Marist Catholic College North Shore (SSD-10473)
Response to Submissions

ATTACHMENT 1

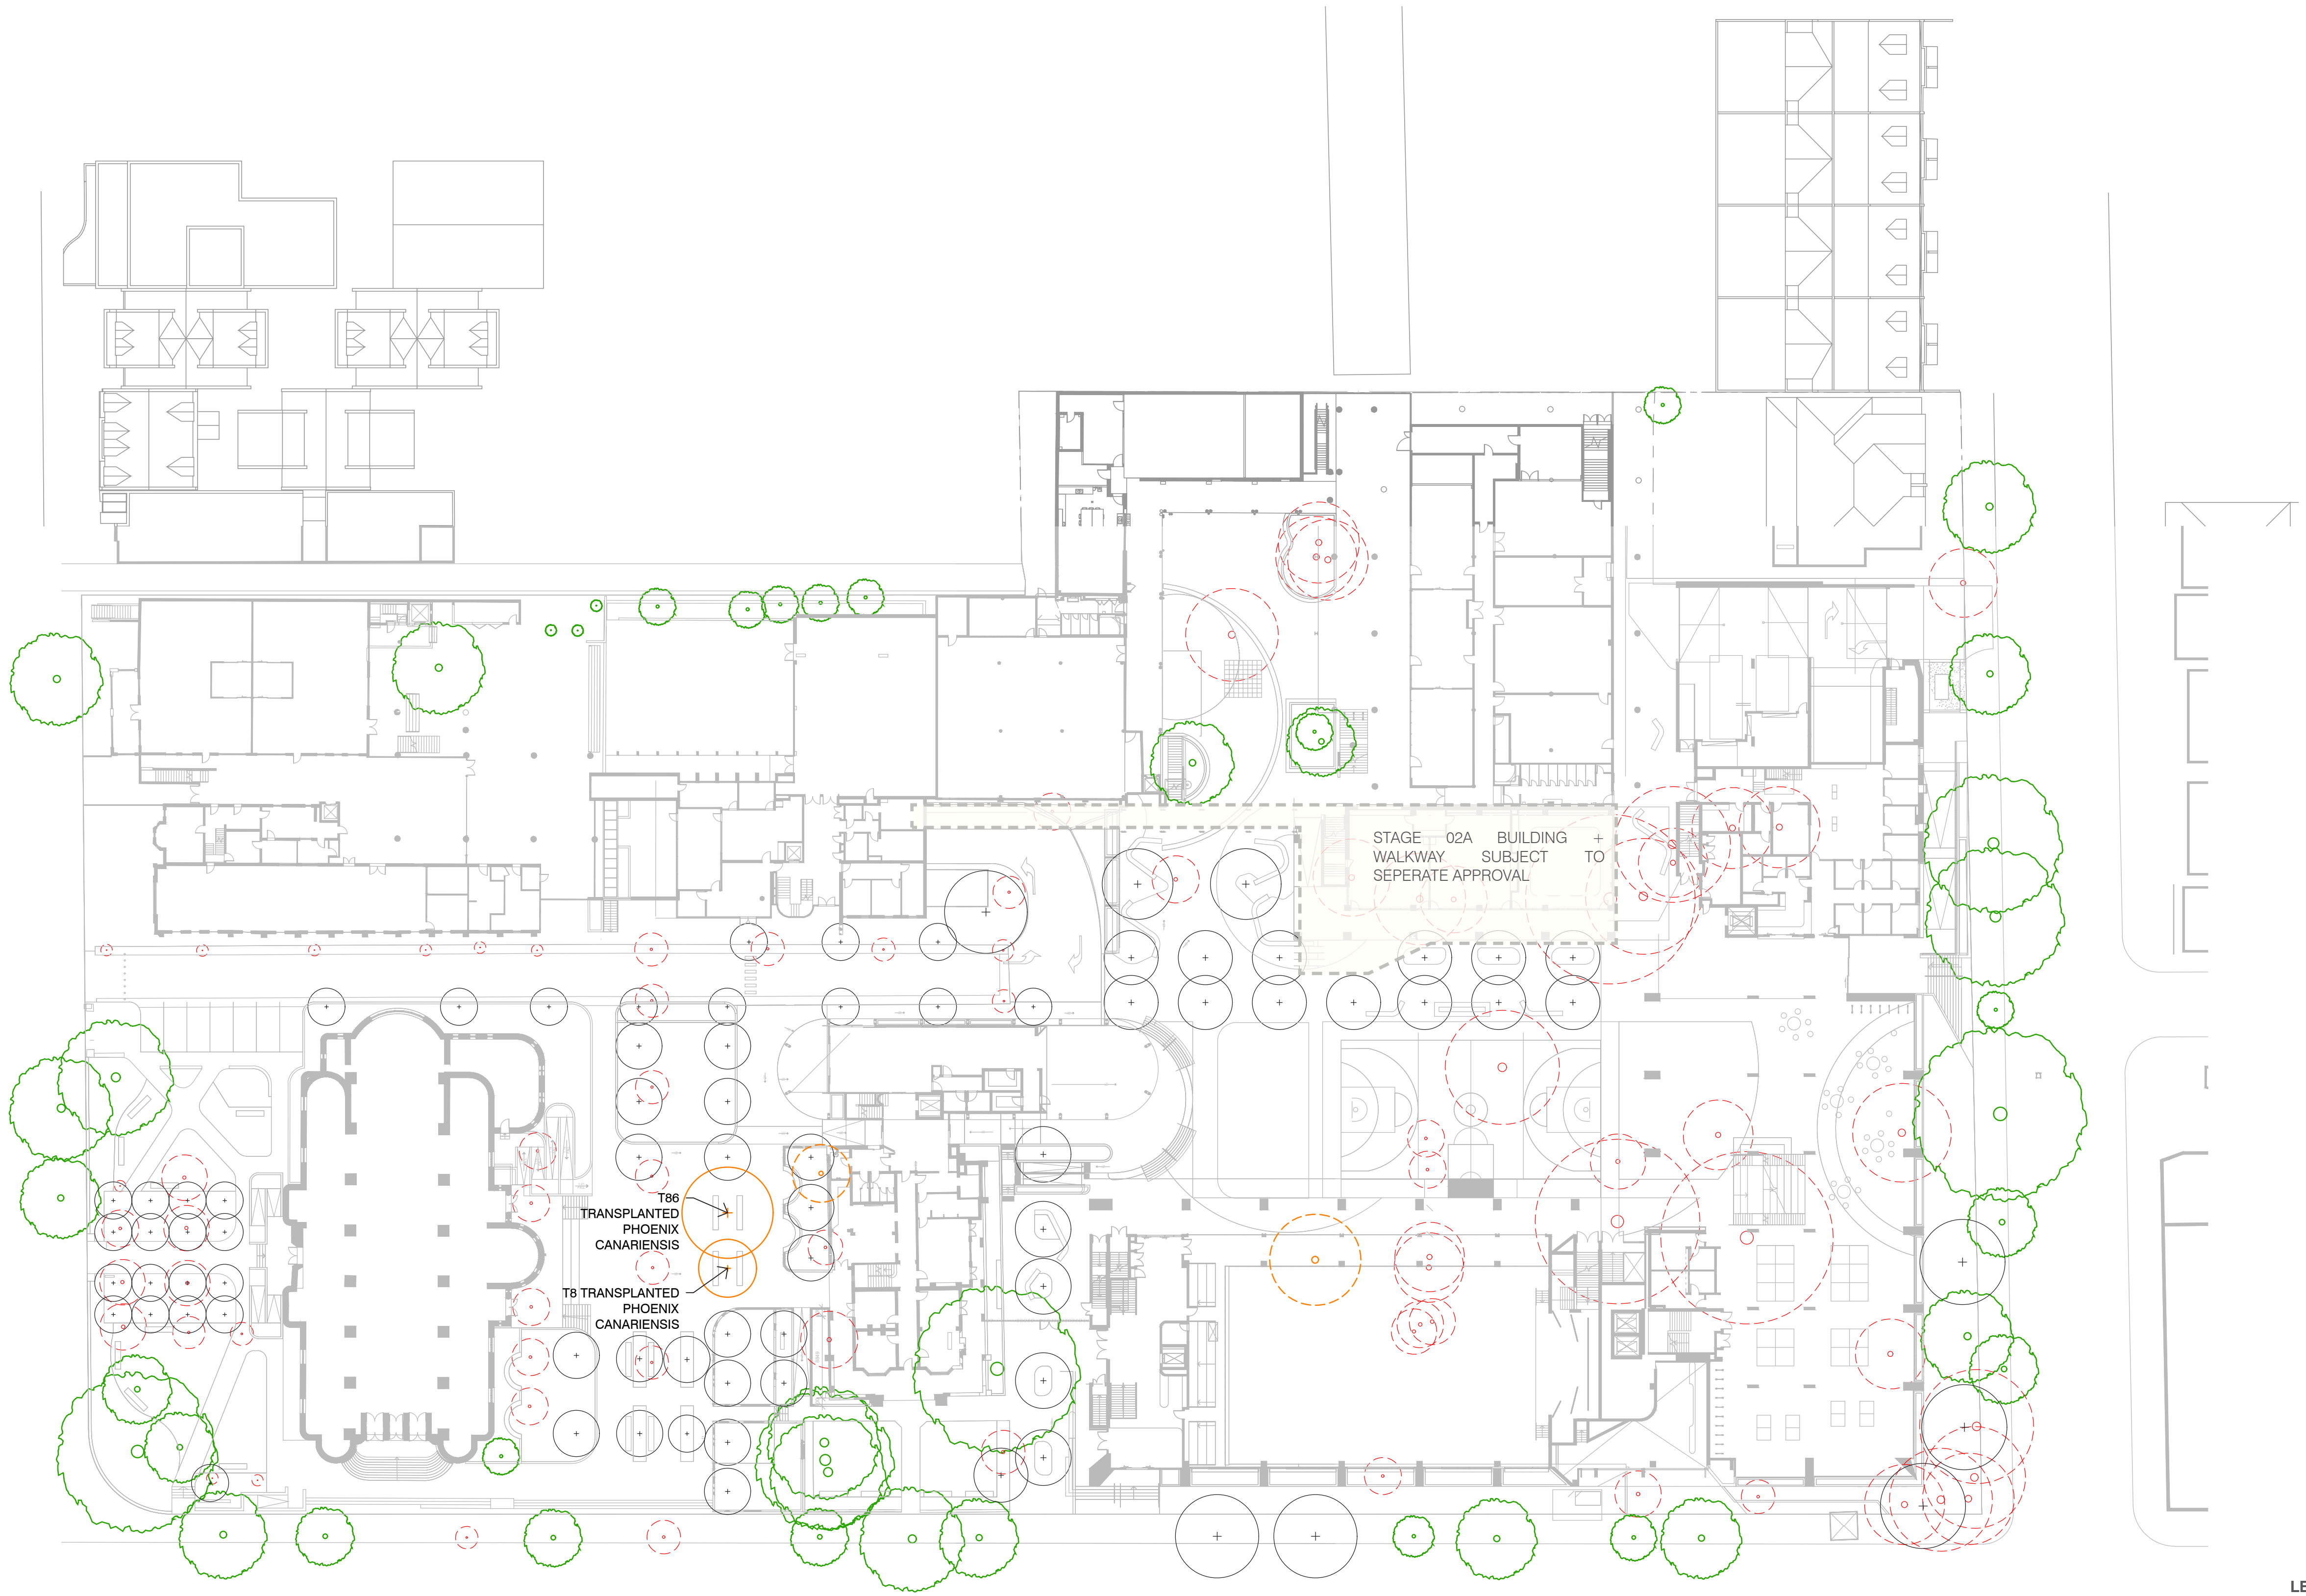
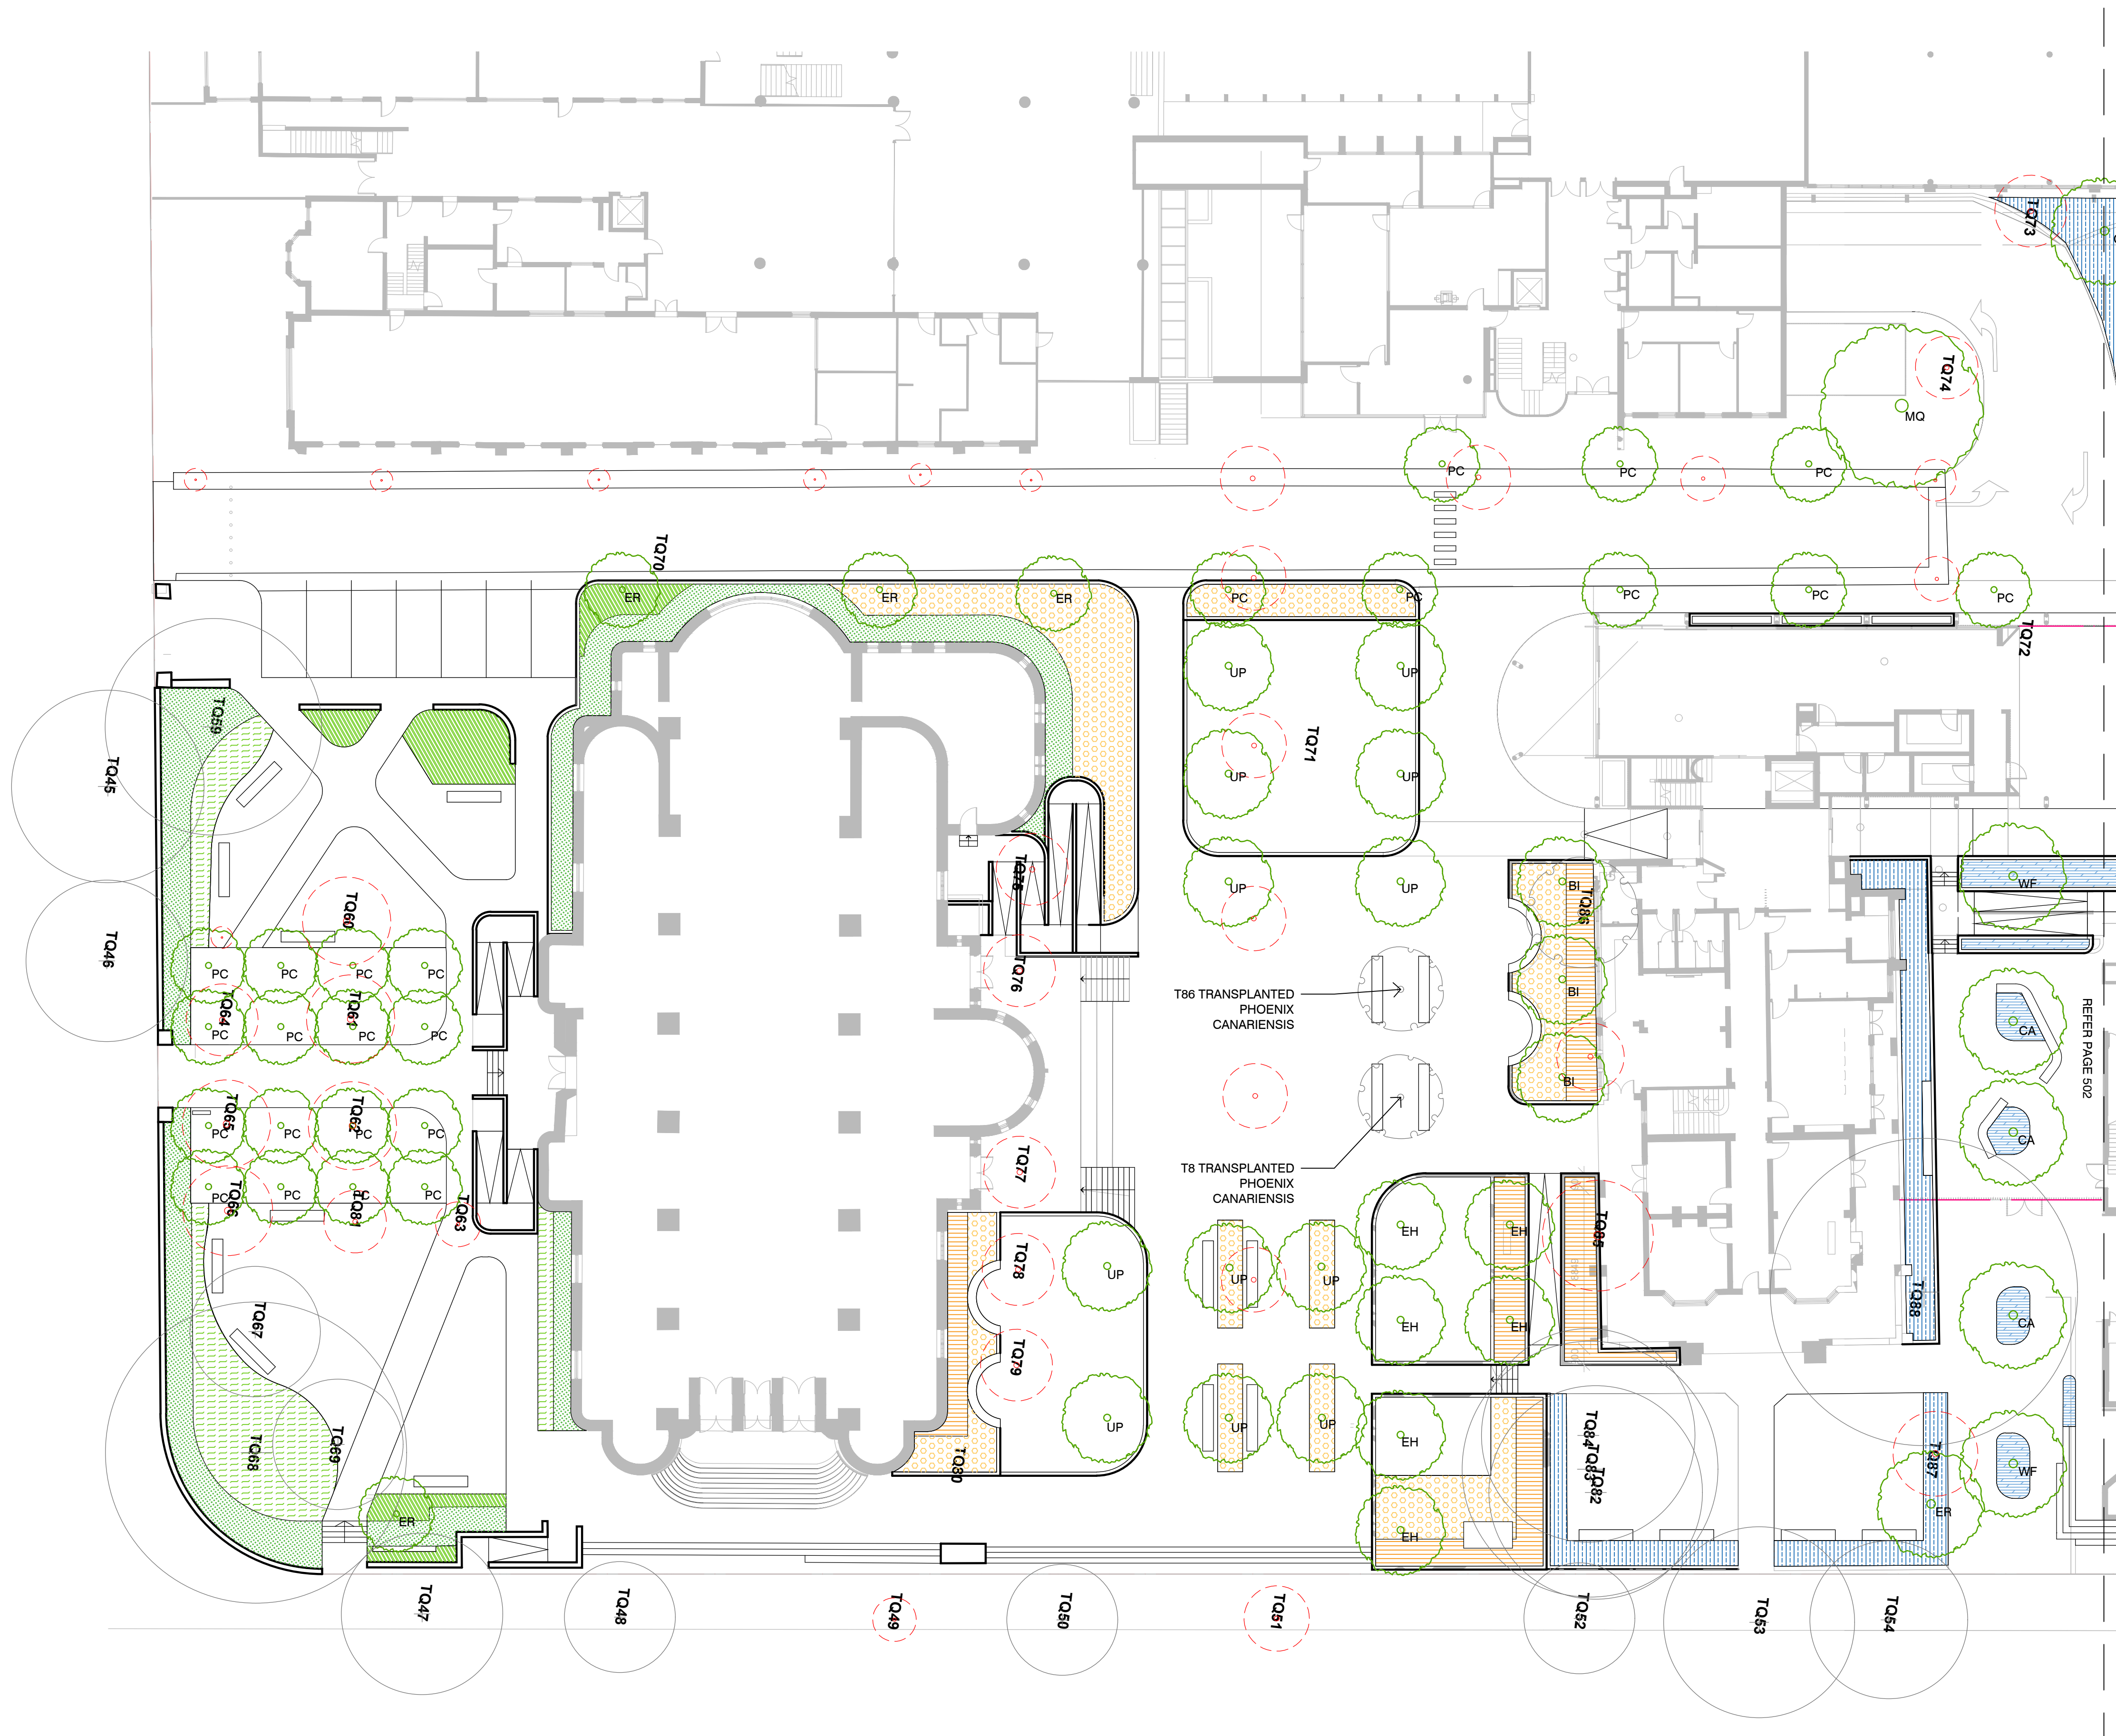
- A revised Landscape Plan that provides exact details of planting locations, species, quantities and pot size is to be submitted in the architectural drawing package.
